**Our Case Number:** ABP-314724-22

**Re:** Railway (Metrolink - Estuary to Charlemont via Dublin Airport) Order [2022]  
Metrolink. Estuary through Swords, Dublin Airport, Ballymun, Glasnevin and City Centre to Charlemont, Co. Dublin

**RE: SUBMISSION ON THE METROLINK ON BEHALF OF EARLDEV PROPERTIES UNLIMITED COMPANY IN RELATION TO PROPERTY AT 13-14 EARLSFORT TERRACE, REAR OF 15-18 EARLSFORT TERRACE AND 17-19 HATCH STREET LOWER, DUBLIN 2 (AND ALSO KNOWN AS 10 EARLSFORT TERRACE)**

**ABP Ref. NA29N.314724**

Drawing Title  
**Figure 14.2 Groundborne Noise from Tunnel Boring Machine Sheet 6 of 7**

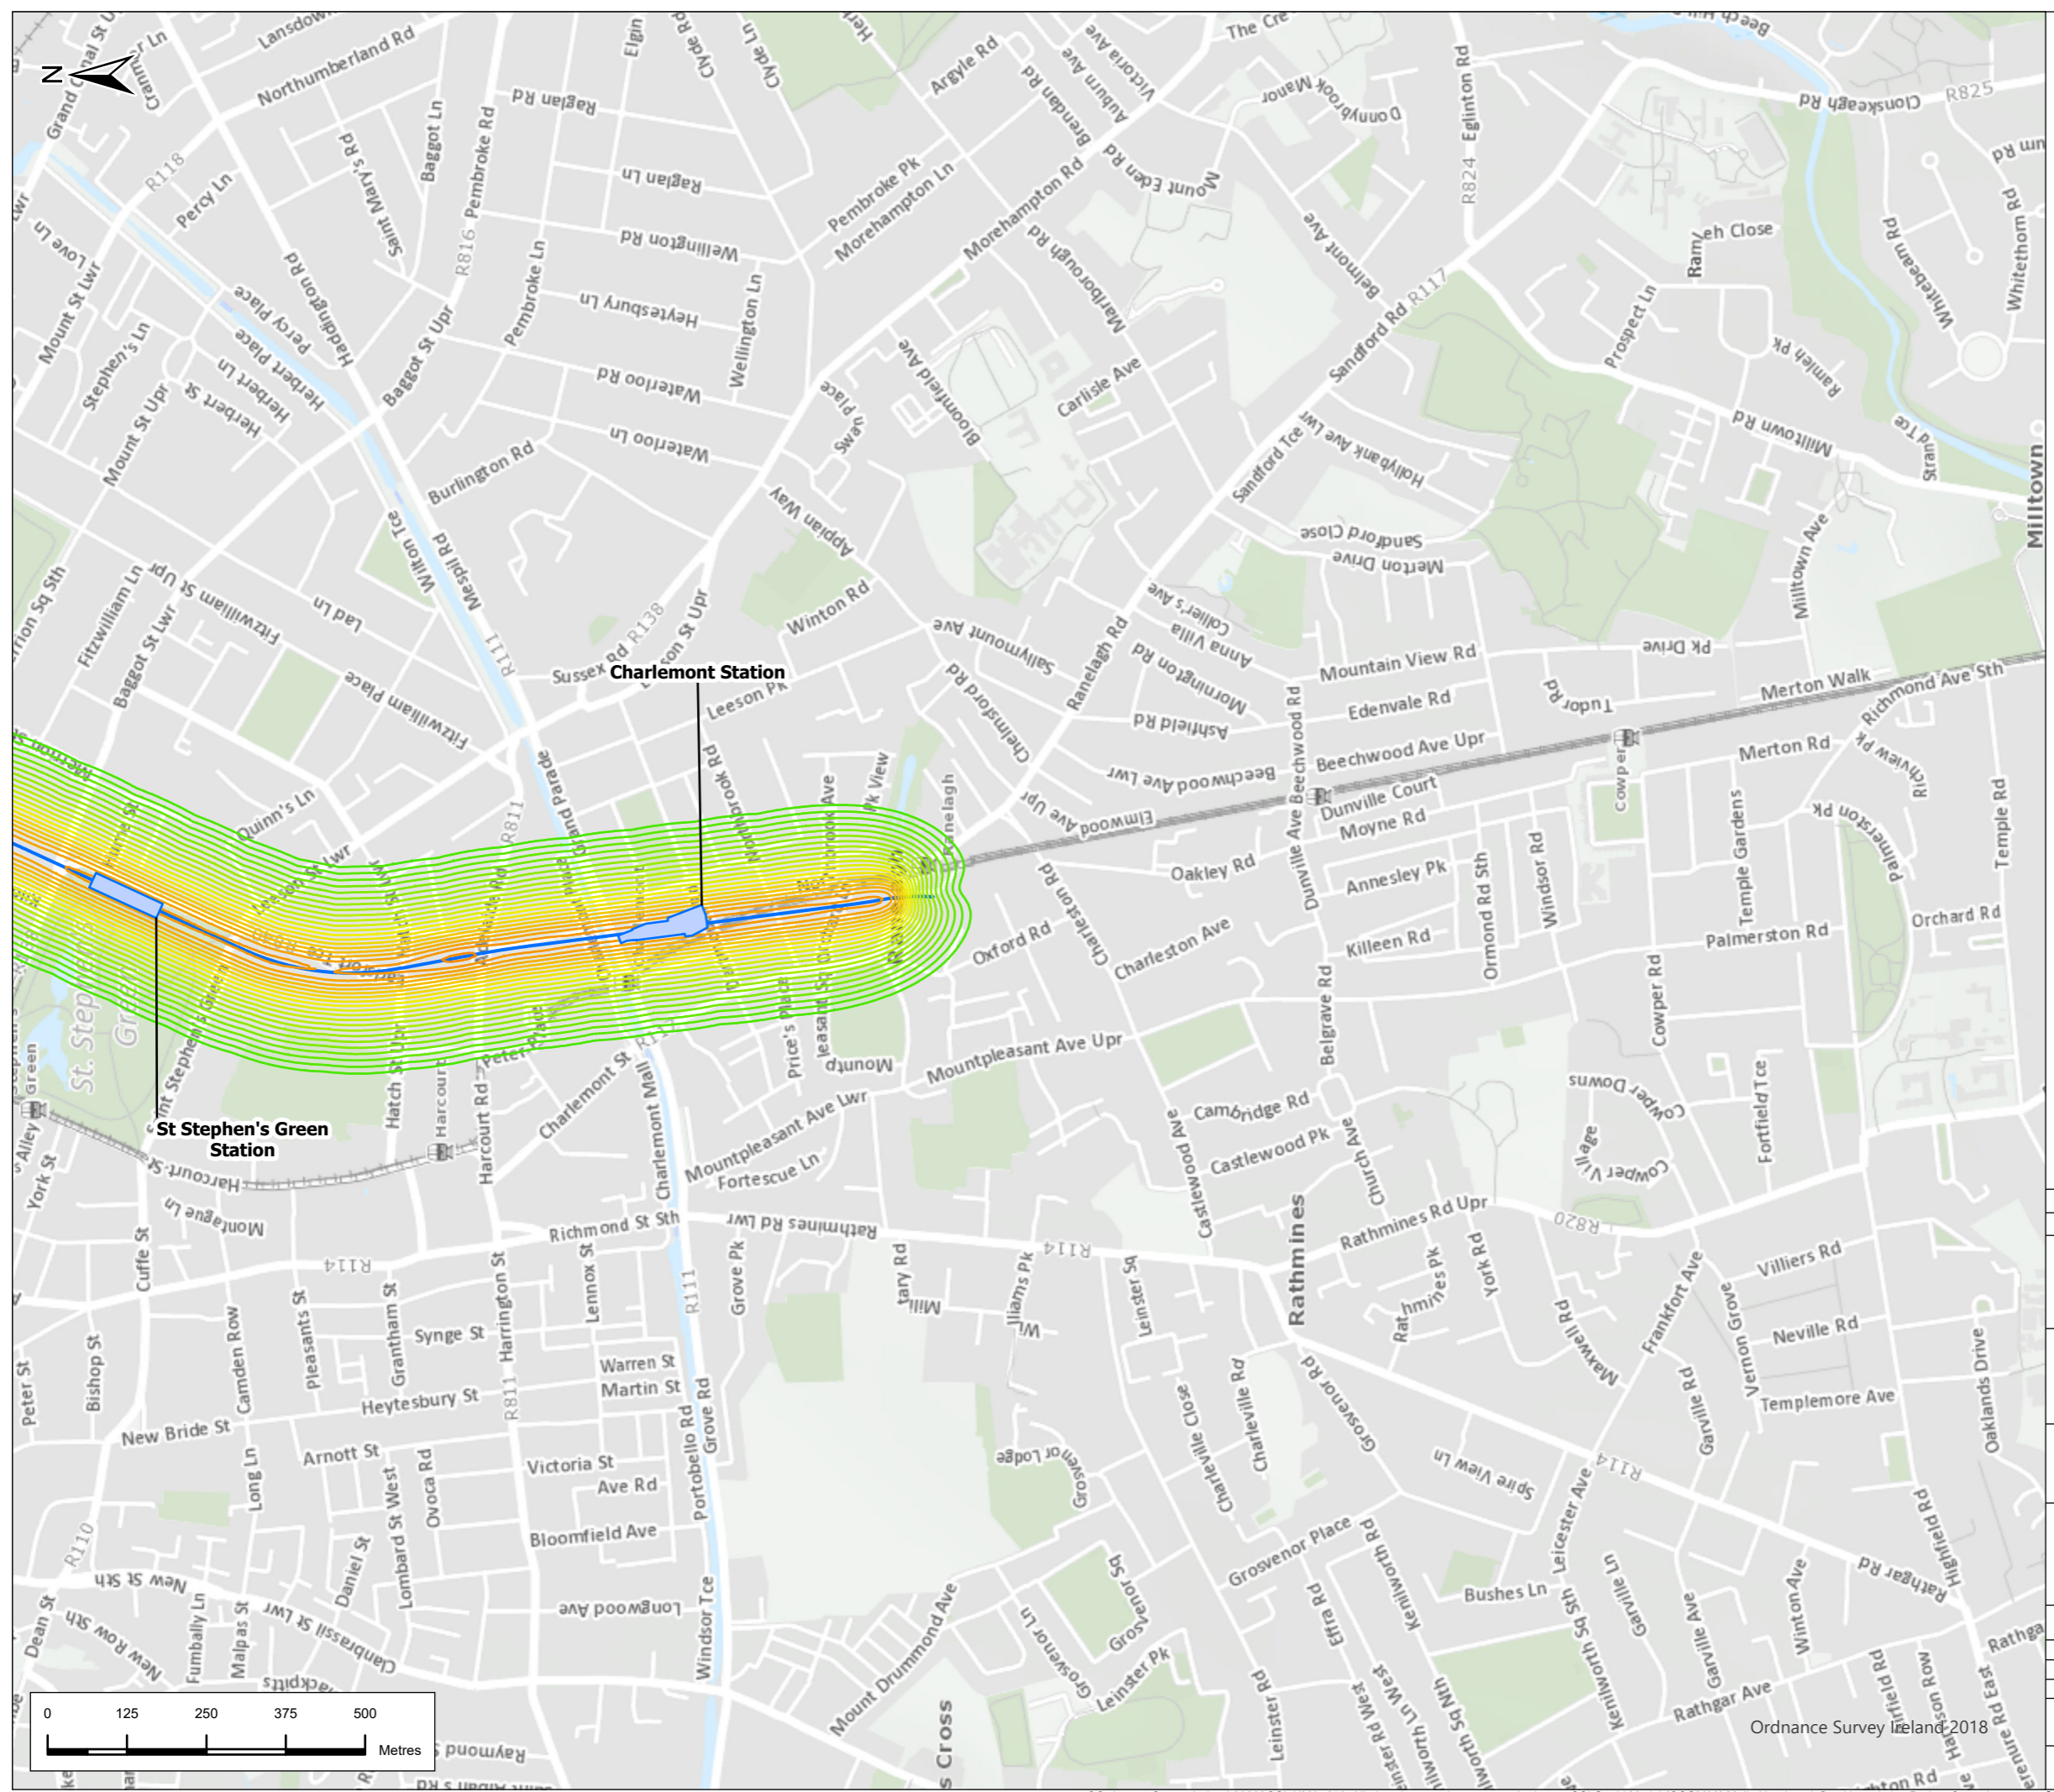
However, our client has serious concerns in relation to the identified noise and associated disruption contained within the Railway Order documentation. A "Very High Adverse (significant)"<sup>1</sup> residual impact is identified to a neighbouring building (20 Earlsfort Terrace). Whilst this impact is noted as being short term, there is no clarity or estimate provided beyond this in relation to the duration of the works due to take place in the vicinity of our client's property.

The Railway Order applies for a vertical deviation of 5 metres upwards. Whilst it is understood a deviation may be required due to detailed design or conditions encountered, the result of such a deviation in relation to the subject property is potential minimal distances (of as little as approximately 350 millimetres) of clearance between the MetroLink construction activities and the subject building substructure with increased significant impacts arising in relation to noise, vibration and associated building damage.
